**Planning Application Ref:** BR/35/18/PL

**Location:** Car Parking Site Adjacent to 112 Gravits Lane Bognor Regis

**Description of works:** 2 No. 2 bedroom semi-detached houses with associated parking, bin & cycle store

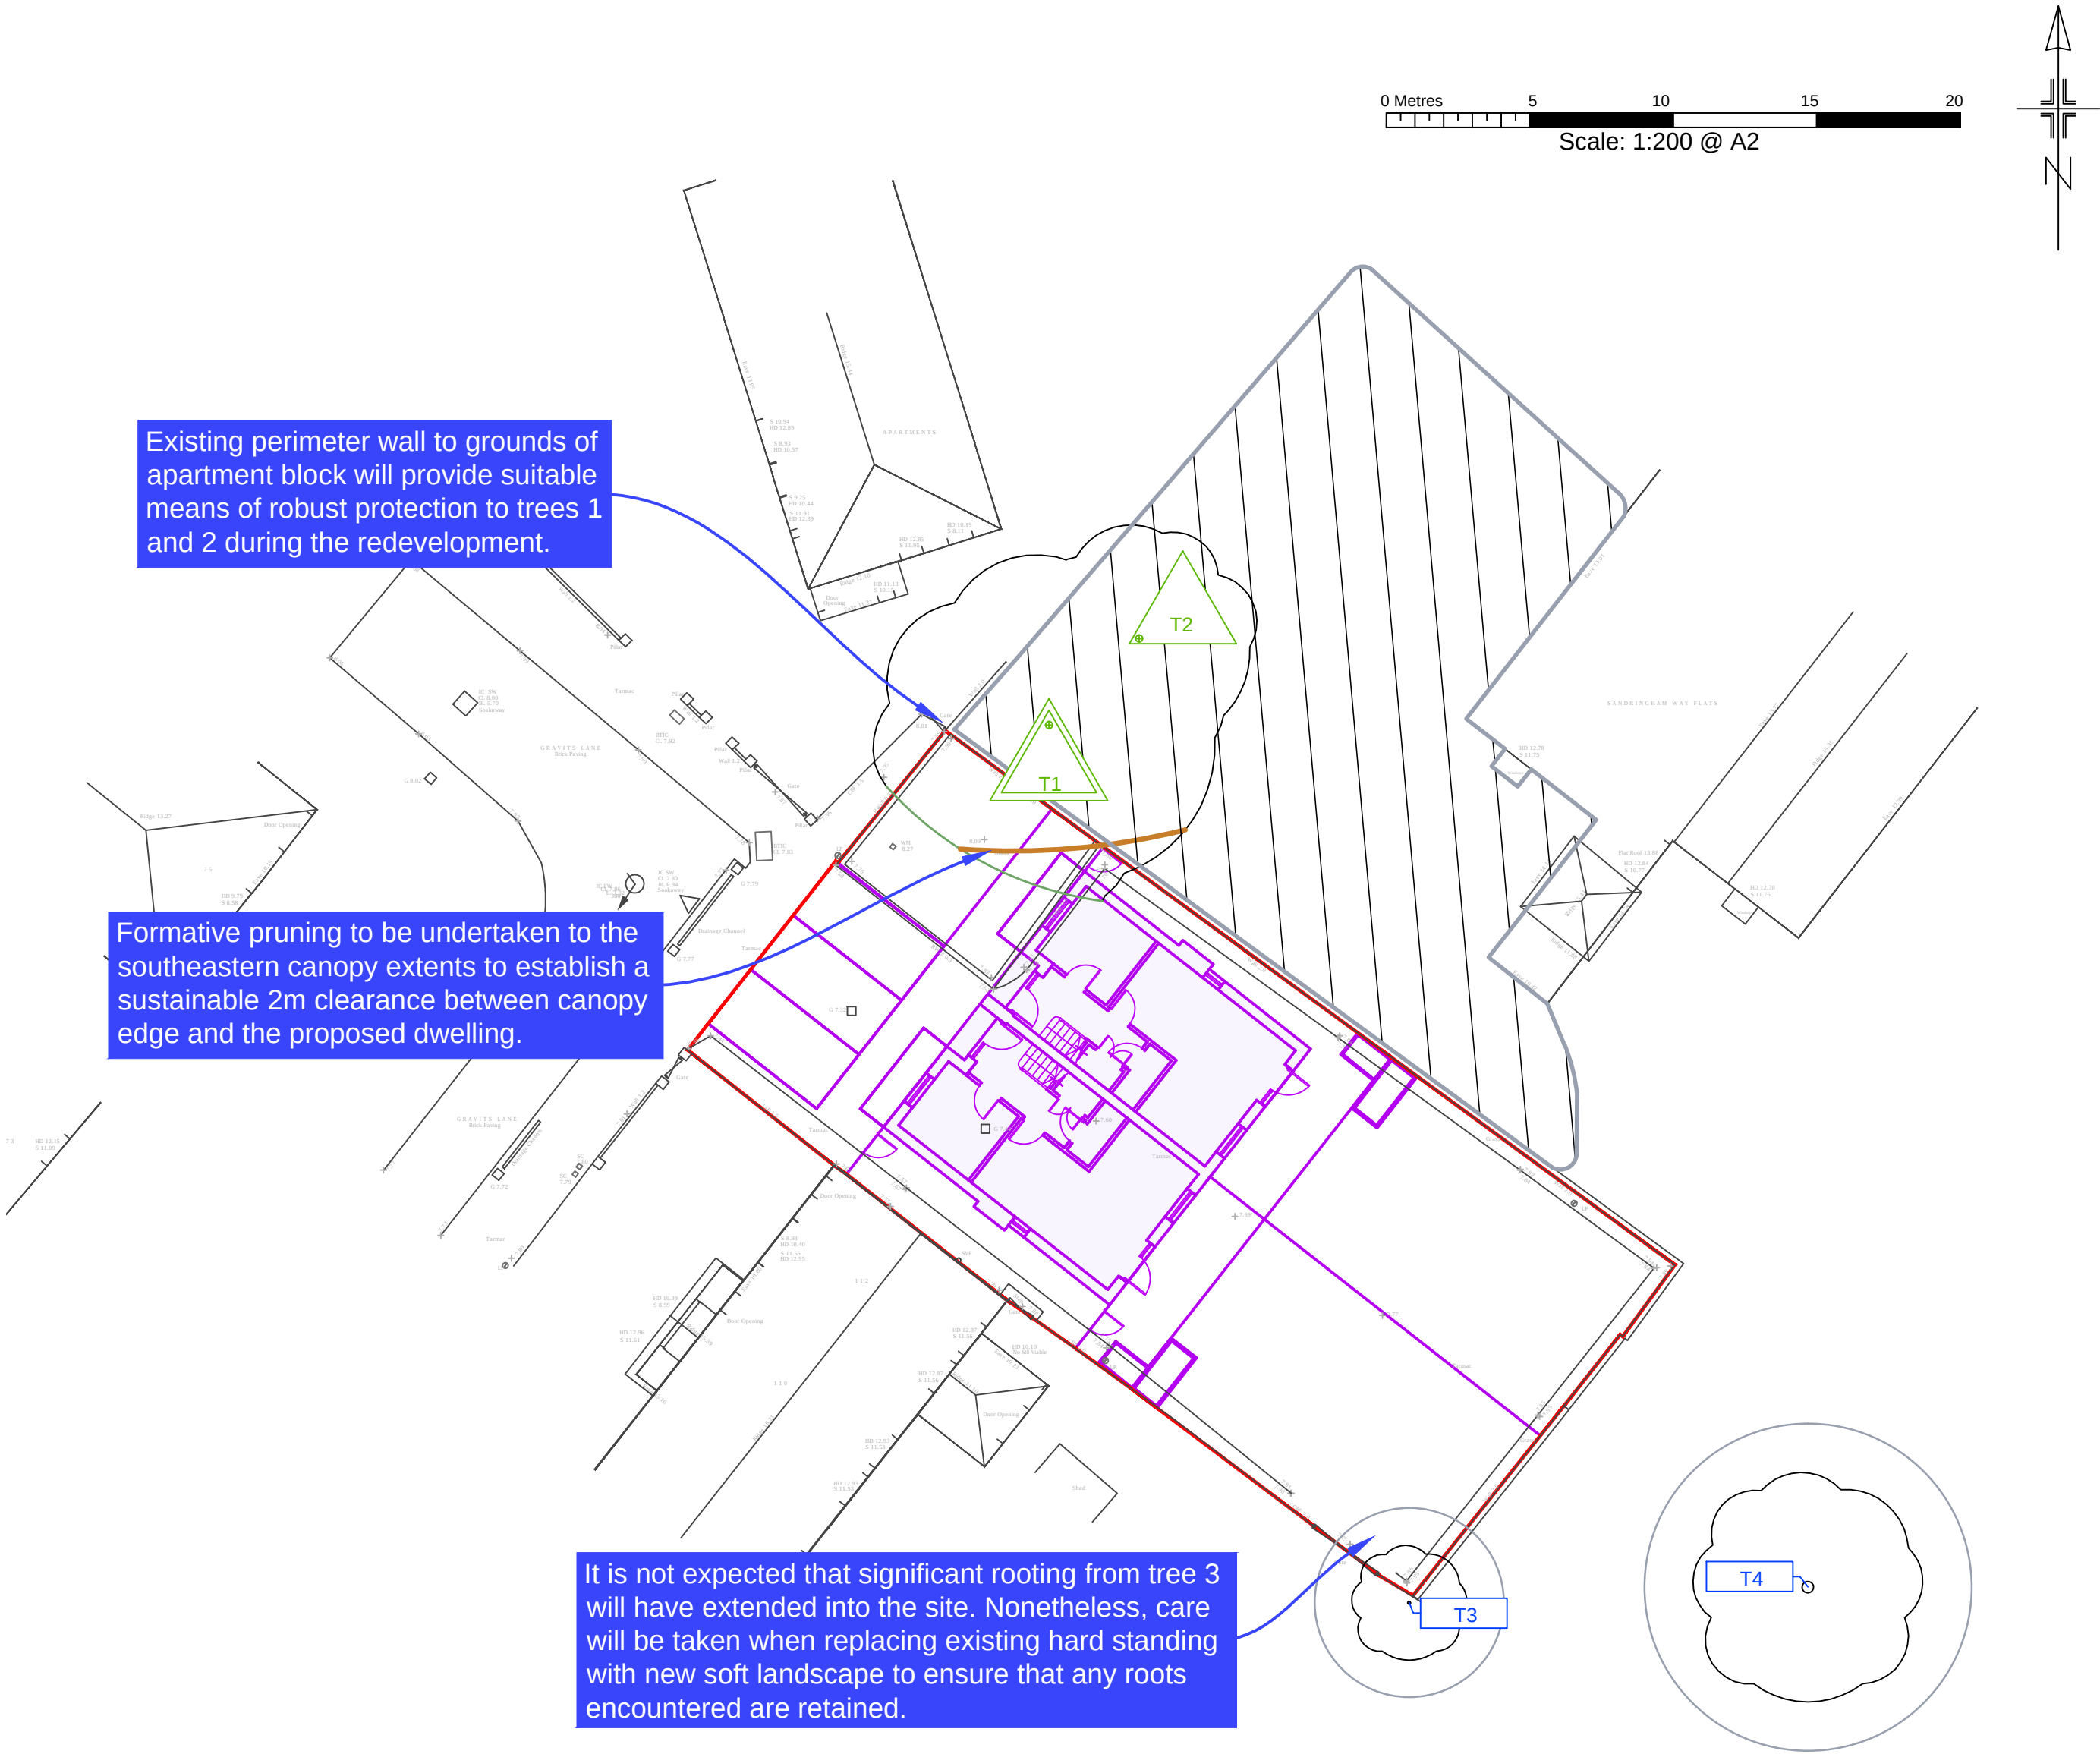
- I seek confirmation of their soft/hard landscaping intentions at the North corner of the site and how they intend to protect any live root material specifically within the raised area and to provide details for any significant alteration to existing levels.

- No Tree Protection Plan has yet been submitted to demonstrate how the perceived RPA of T1 will be effectively secured by way of a Construction Exclusion Zone (CEZ) against disturbance and/or contamination.
